WEST SUSSEX COUNTY COUNCIL CONSULTATION

TO:	Arun District Council FAO: Andrew Wood
FROM:	WSCC - Highways Authority
DATE:	29 June 2020
LOCATION:	Land adjacent to 45 The Ridings, East Preston, BN16 2TW
SUBJECT:	EP/67/20/PL 1 No. detached house & formation of associated new access.
DATE OF SITE VISIT:	N/A
RECOMMENDATION:	Advice
S106 CONTRIBUTION TOTAL:	N/A

B	GARAGE SIZE AMENDED AND WINDOWS TO NORTH ELEVATION ADJUSTED	01.07.20
A	STREET ELEVATION ADDED	07.04.20
REV	DESCRIPTION	DATE

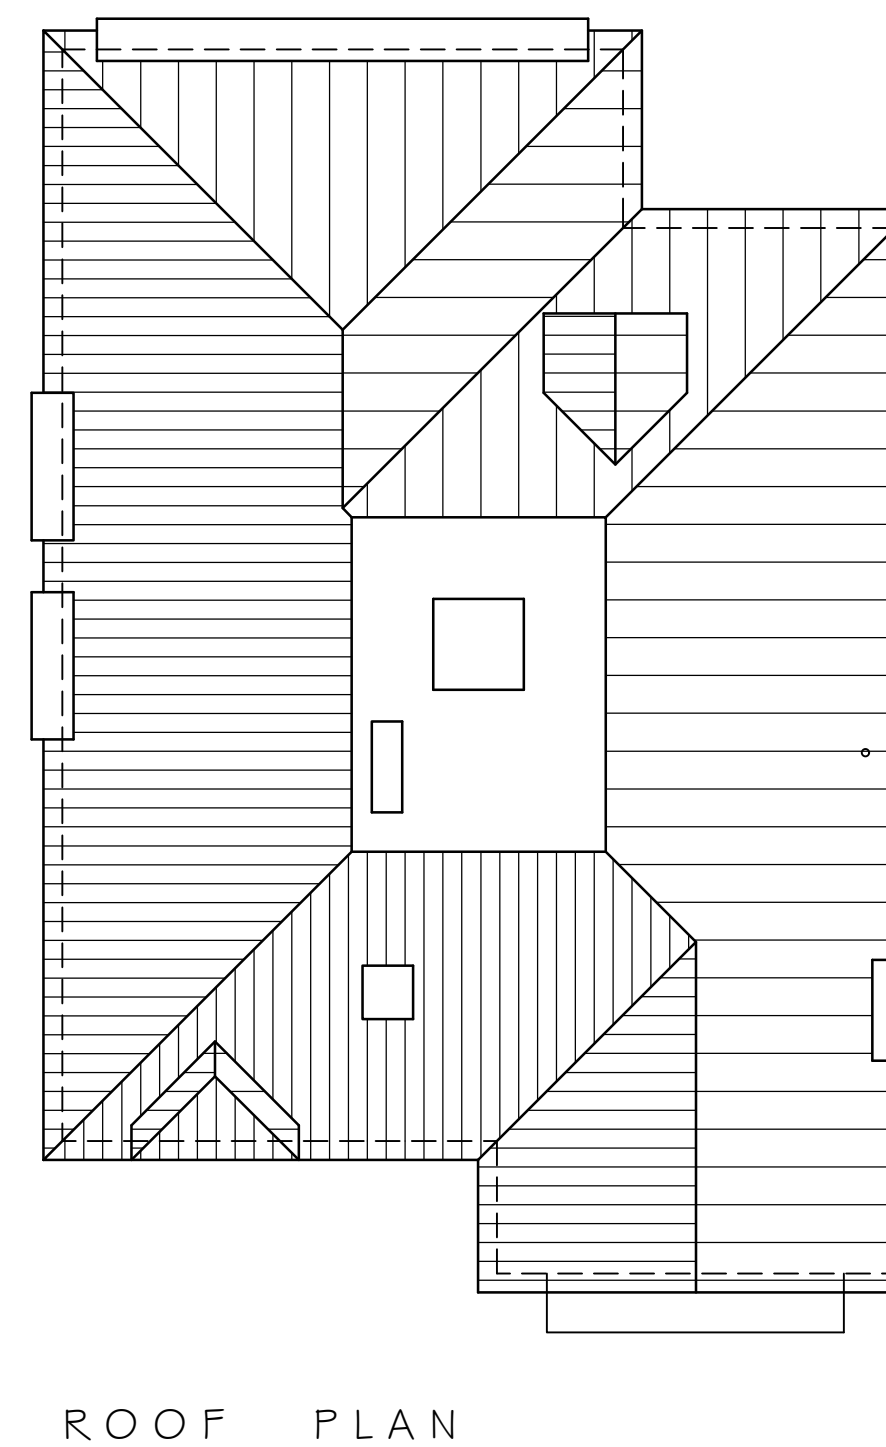
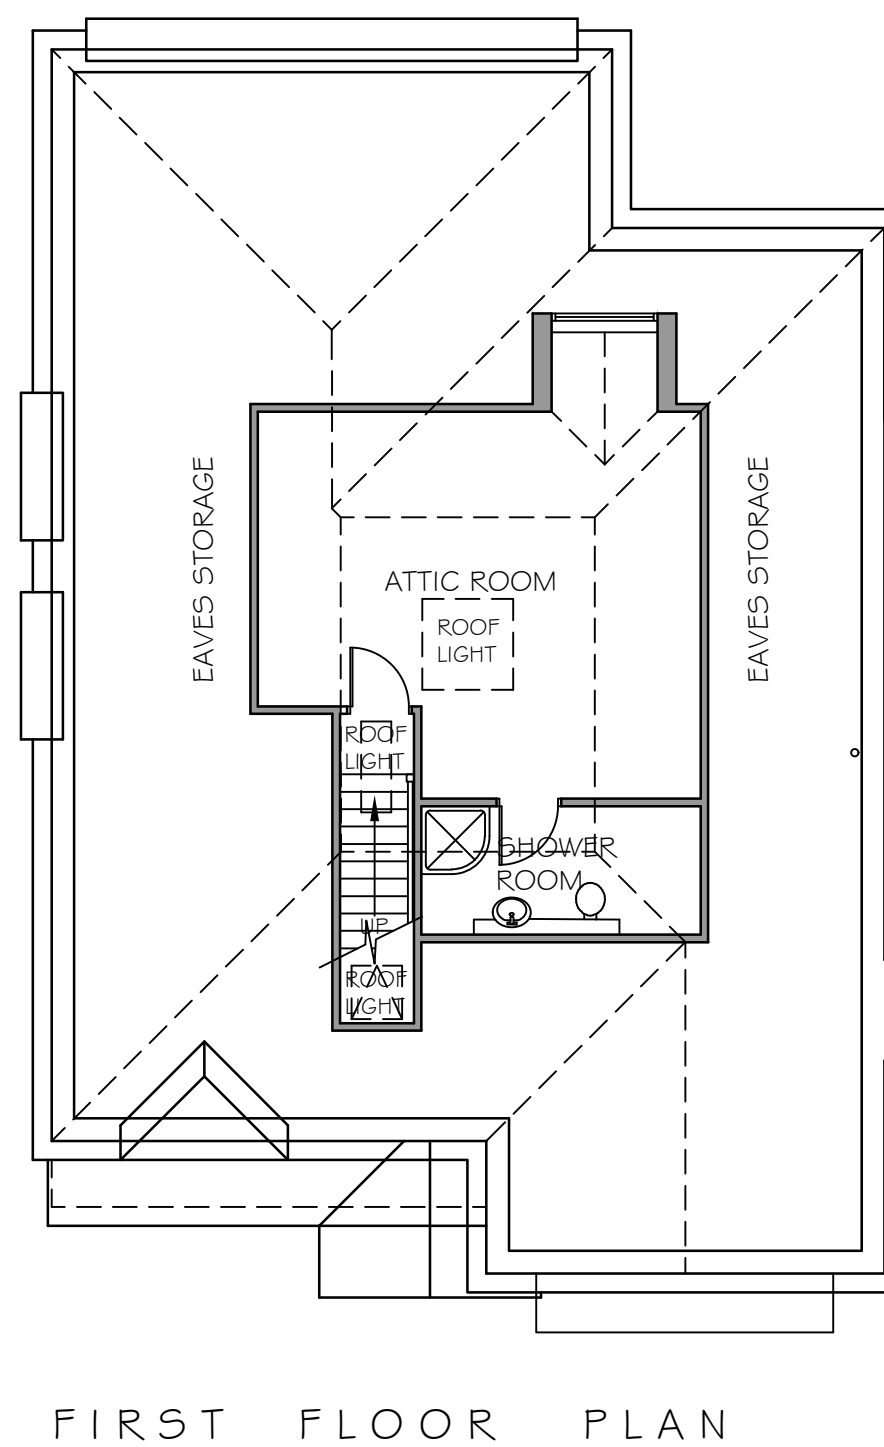
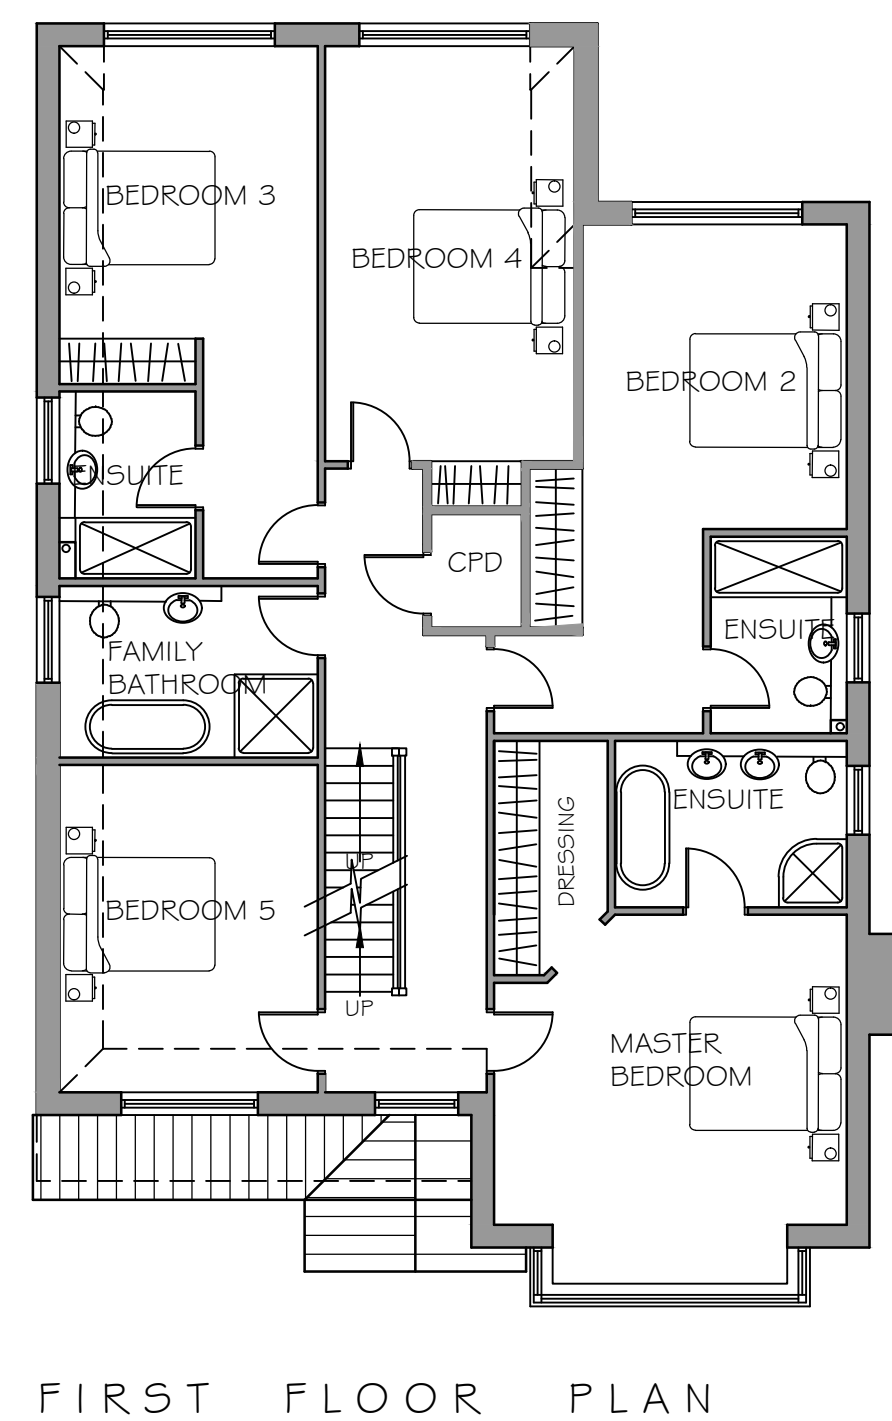
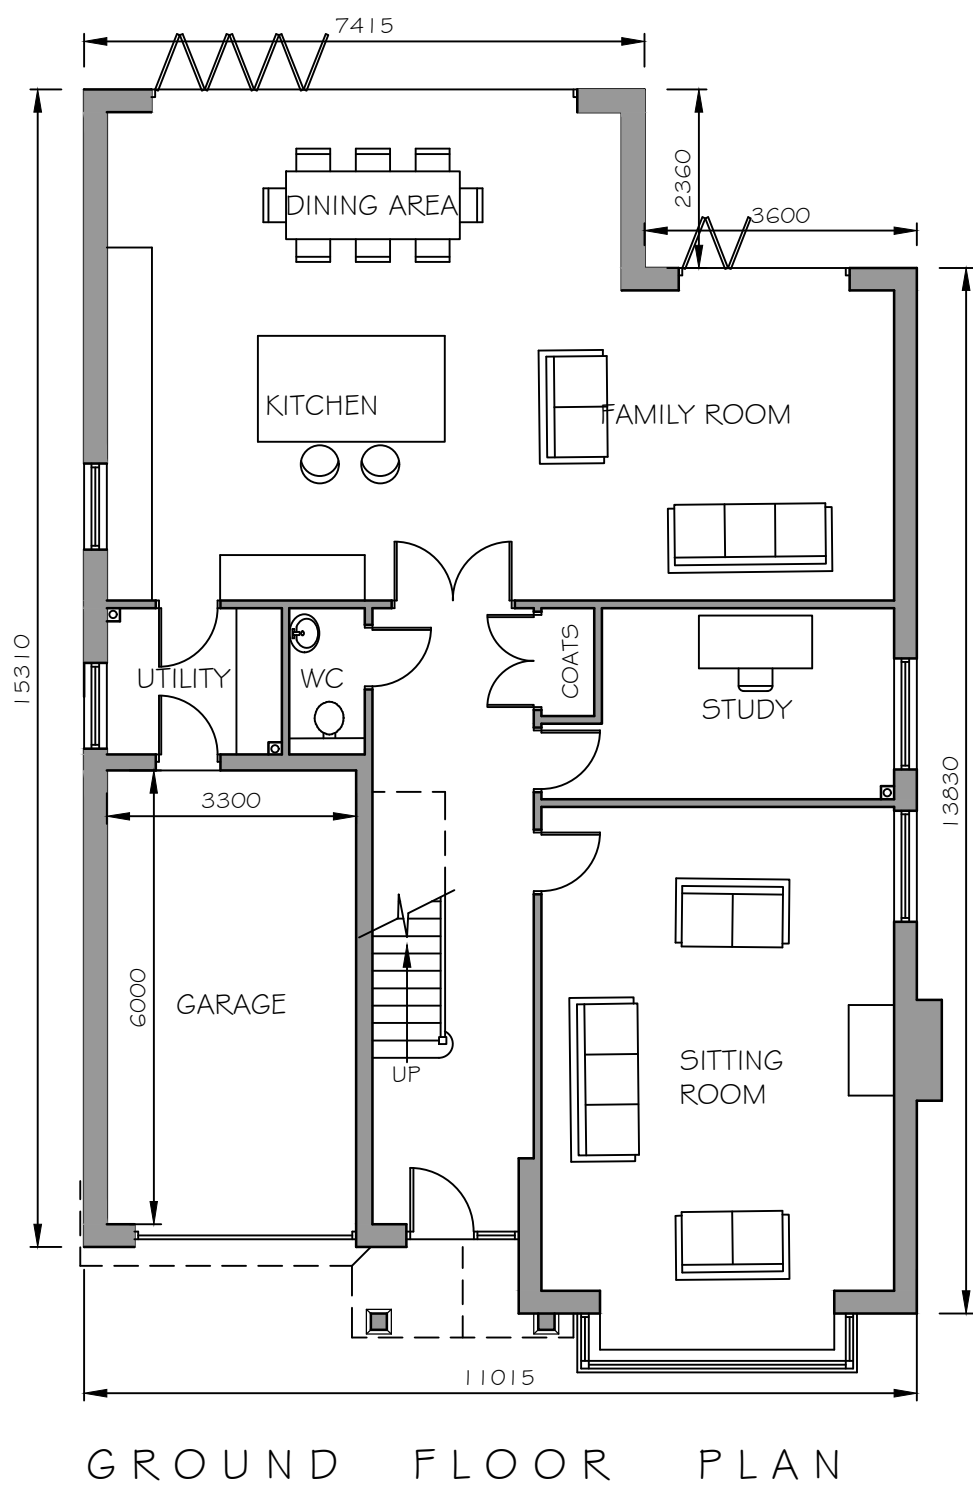
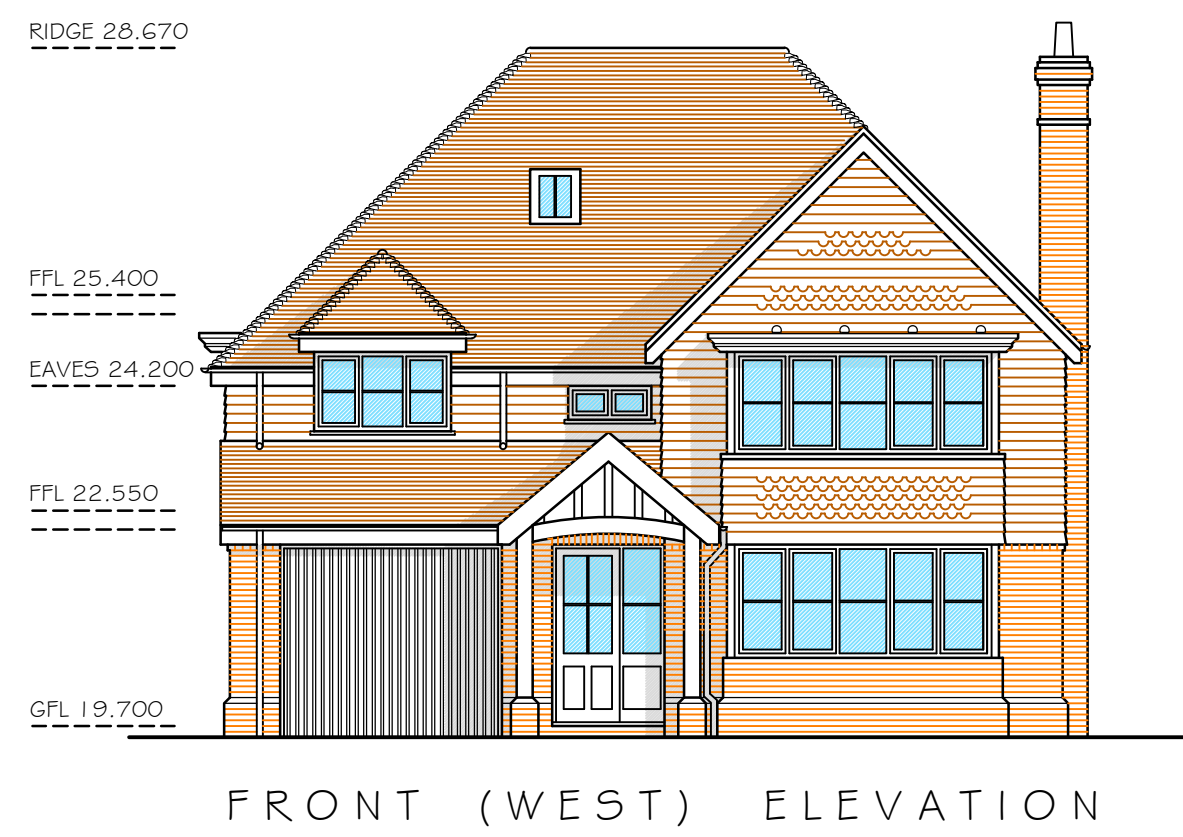
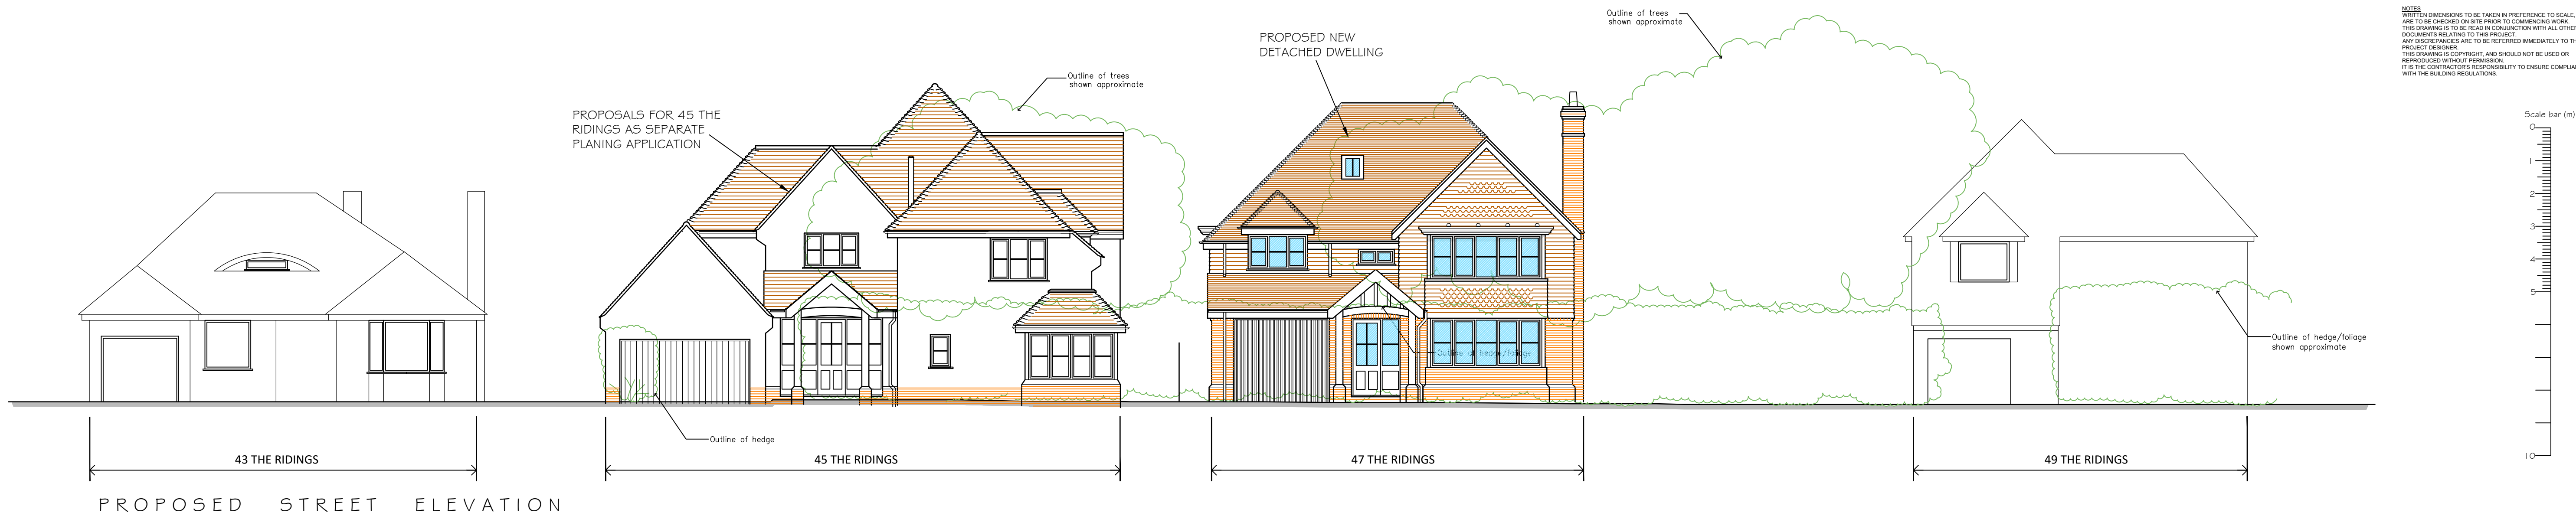
The LHA notes that the proposed garage does not meet the minimum specifications for single car garages of 3m x 6m as set out in Manual for Streets (MfS). The LHA advises the applicant to modify the plans to ensure the garage meets MfS specifications. Notwithstanding this, the LHA is satisfied that the plans demonstrate adequate parking provision.
